**Office of
Environment
& Heritage**

RE: REVIEW OF BENGALLA MINE – MODIFICATION 5 ENVIRONMENTAL ASSESSMENT – SECTION 75W MODIFICATION (DA 211/93)

ATTACHMENT 1: COMMENTS AND RECOMMENDED CONDITIONS OF APPROVAL FOR PROPOSED BENGALLA MINE – SECTION 75W MODIFICATION 5 TO DA 211/93

Indicative Test Pit and Borehole Locations

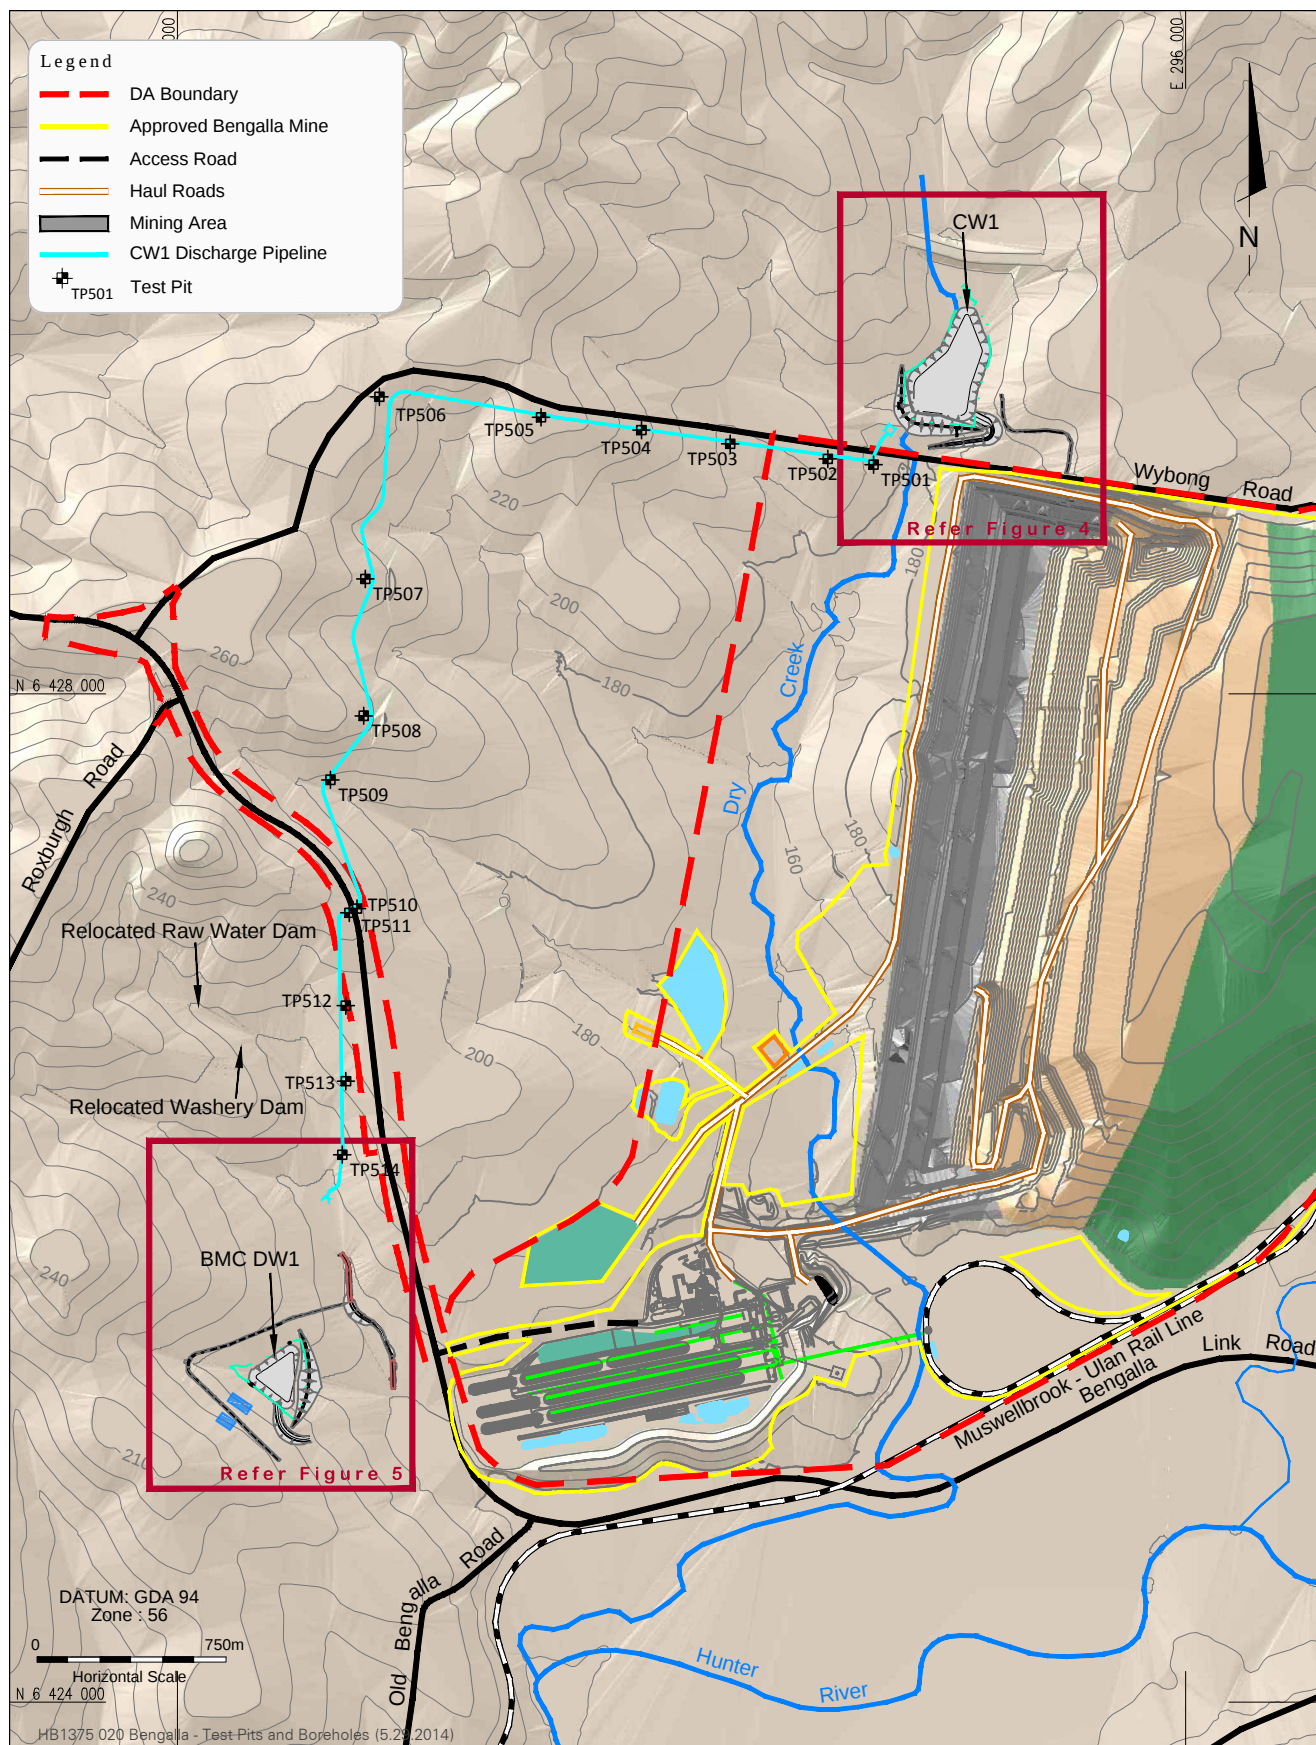
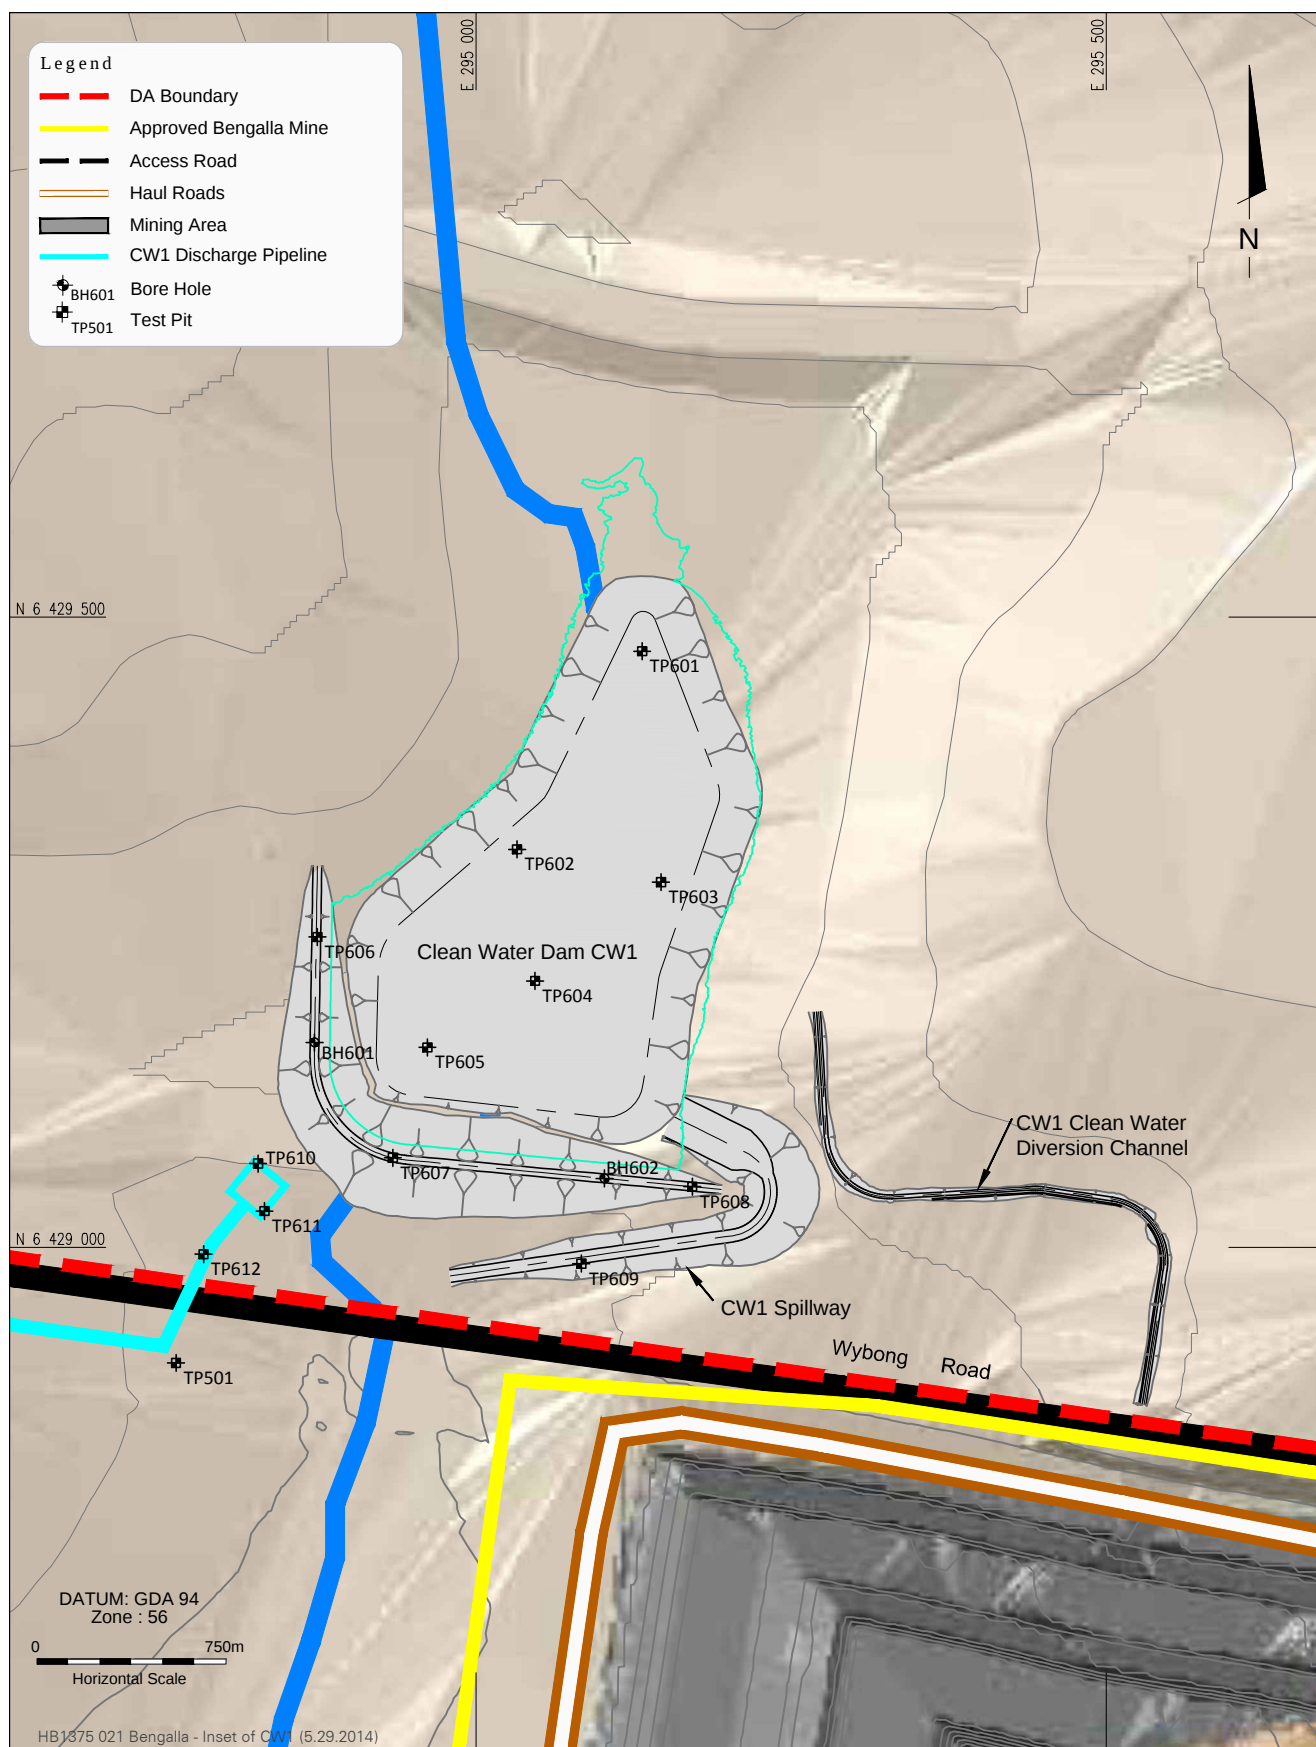
- the number of test pits to be excavated is only approximate
- the test pit surface disturbance area doesn't appear to allow for activities associated with the excavation of the test pits
- the pipeline route and therefore location of the test pits hasn't been confirmed
- it is unclear to what extent any new tracks will require 'clearing'.

The EA states that the location of the pipeline and Wybong Road test pits are indicative only as the route of the pipeline has yet to be confirmed, in addition the EA states that 'approximately 51' test will be excavated though it does not provide any information regarding to what degree that location and number may vary.

In addition the EA states that the excavation of the test pits will result in a surface disturbance area of no greater than 4m x 4m but does not provide details as to what activities will be restricted to that 4m x 4m. The EA does not appear to make allowances for the temporary stockpiling of topsoil and spoil nor does it appear to allow for the placement of the excavation equipment. Both these impacts can potentially be mitigated and managed but no details as to how this will be achieved have been provided.

- an upper limit of the number of test pits is to be provided with the impacts to biodiversity considered based on this upper limit, this area will then need to be included into the total area of disturbance

1. A project report shall be submitted upon completion of works and will include;
 - a. Details of the final location and number of test pits as well as the location of cleared tracks displayed in a figure overlaying Archaeological sites and vegetation mapping;
 - b. Details of mitigation measures applied;
 - c. Photographs of each site taken immediately following rehabilitation; and
 - d. The final area of disturbance must be provided and include types and areas of communities impacted upon.
2. If within 12 months of the modification approval the Bengalla Continuation Project does not receive approval, then Bengalla Mine will provide offsets for the total area of disturbance in accordance with OEH offset principles.

Aboriginal Archaeological Sites and Test Pits

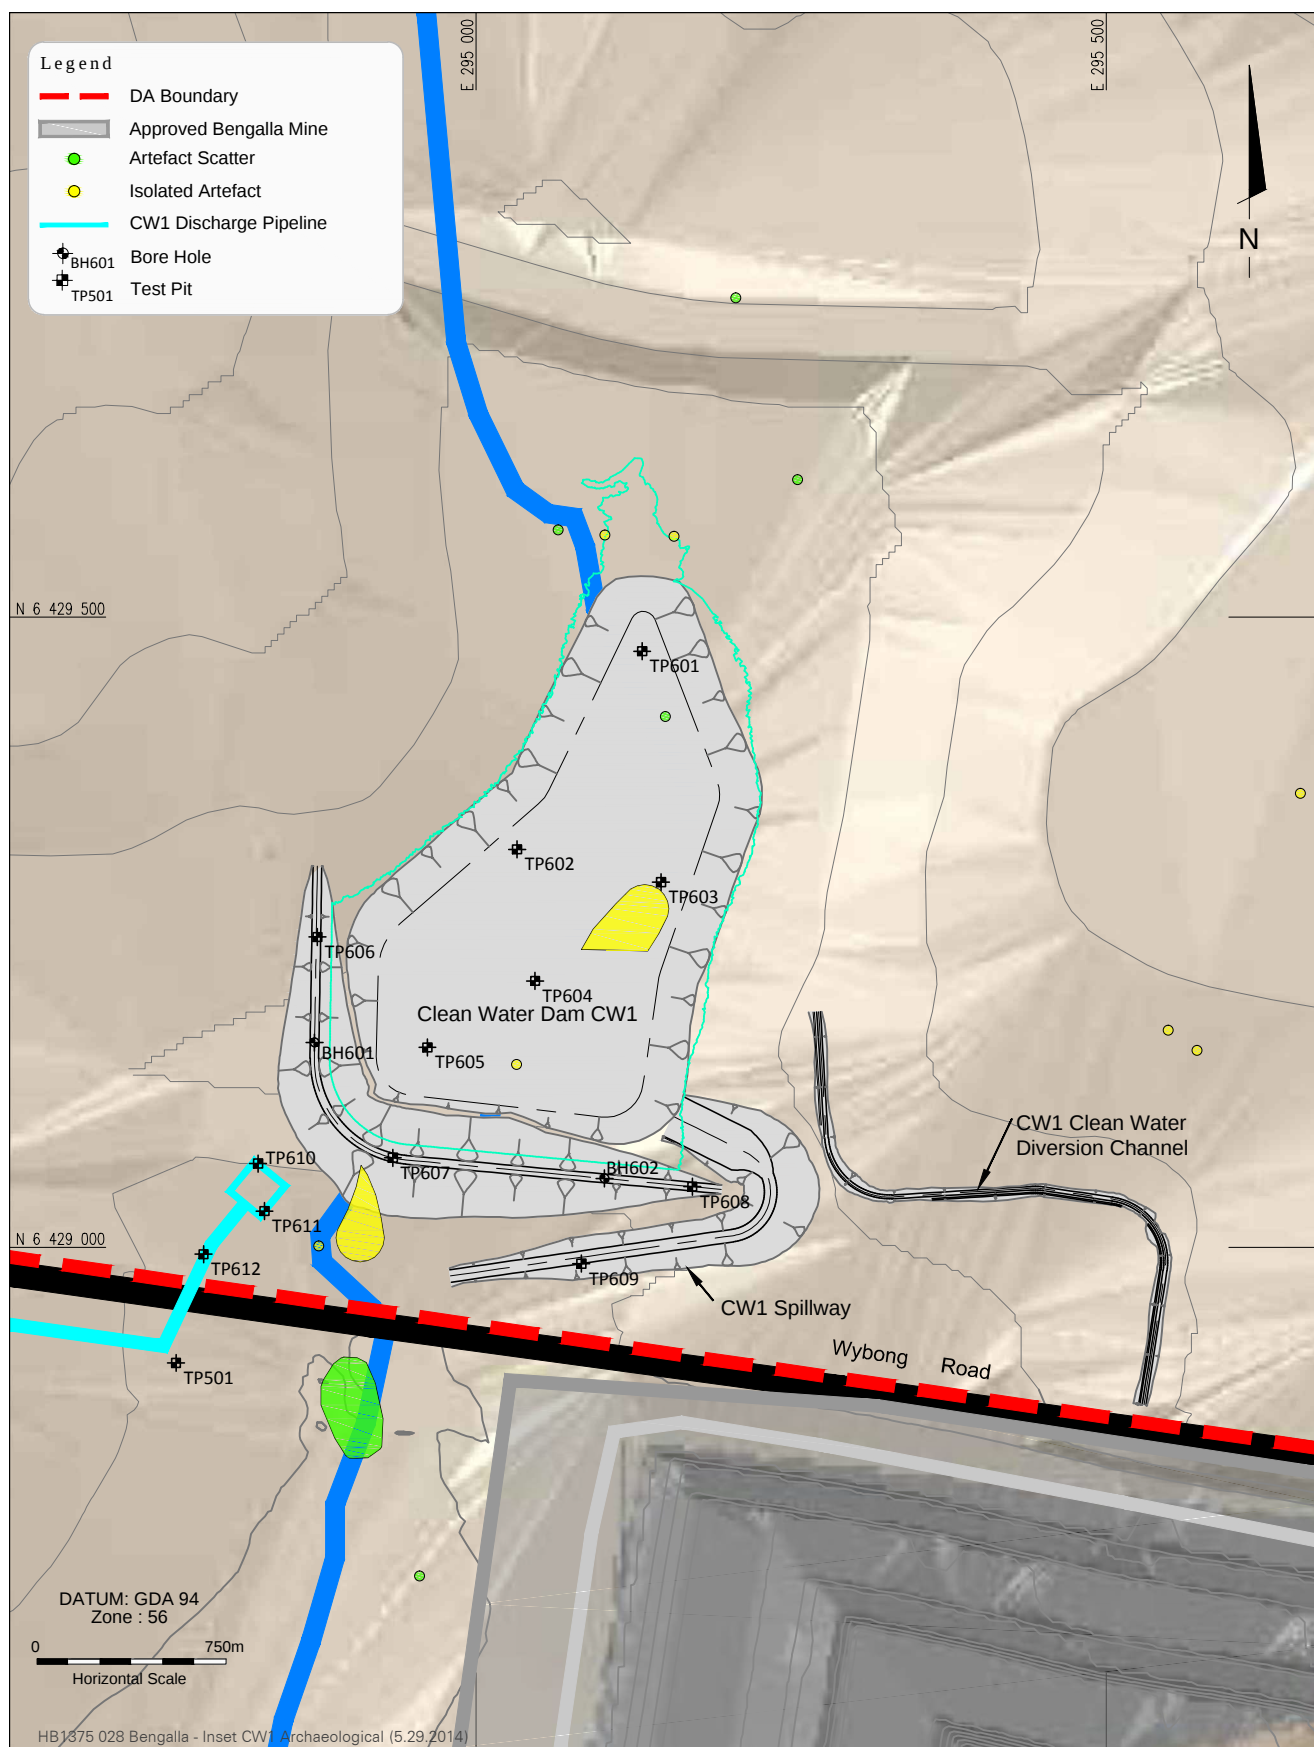
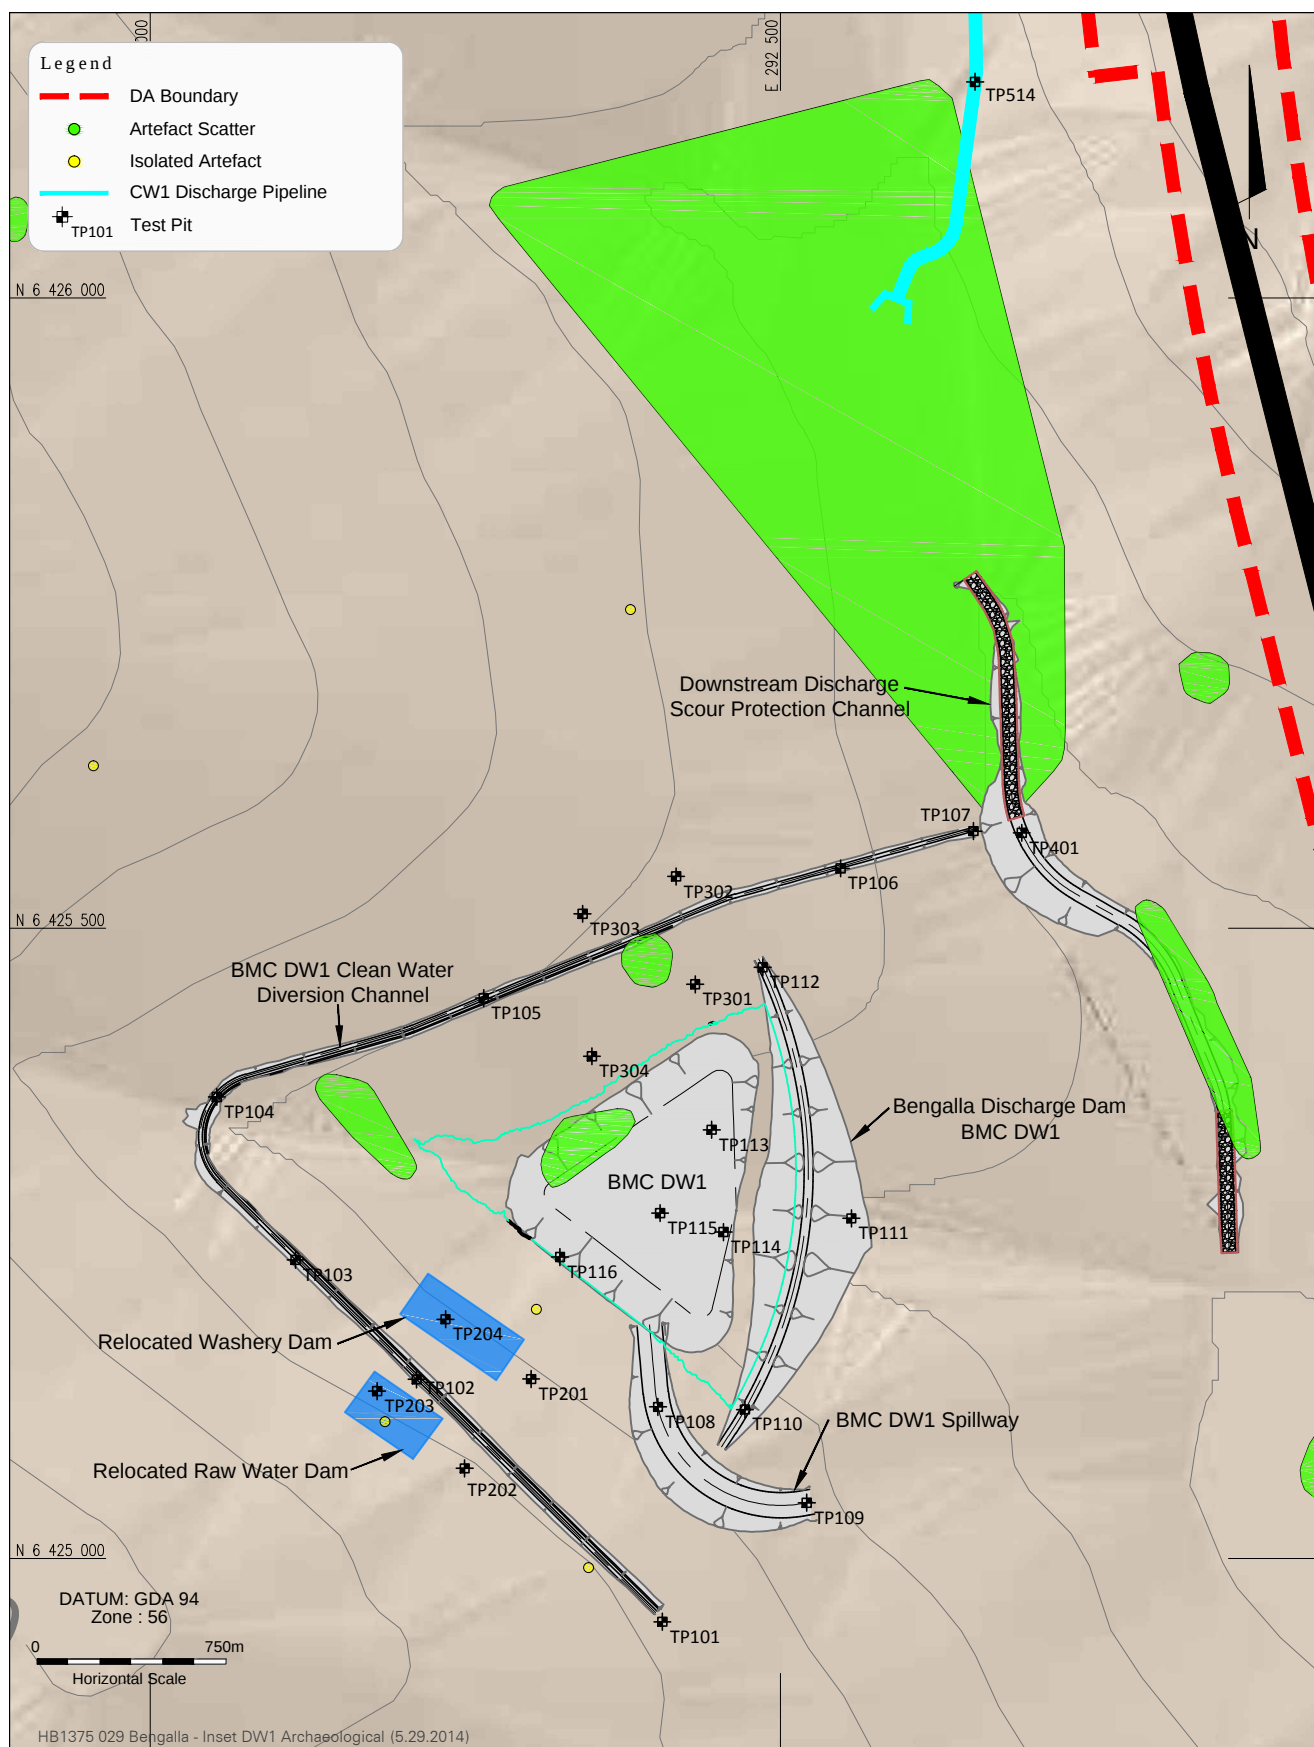
In summary, clarification is required as to the actual area of disturbance and therefore what Aboriginal objects and area of Box Gum Woodland endangered ecological community will potentially be impacted upon.

1. That a Due Diligence Aboriginal Archaeological Assessment under current 2010 OEH guidelines for each test pit and borehole site be undertaken by suitably qualified heritage professional.

2. All recorded Aboriginal objects be clearly marked and suitably fenced off to ensure that no impact occurs.
3. Access to the test pit and borehole locations is clearly demarcated to ensure that all disturbance is contained within the designated footprint.
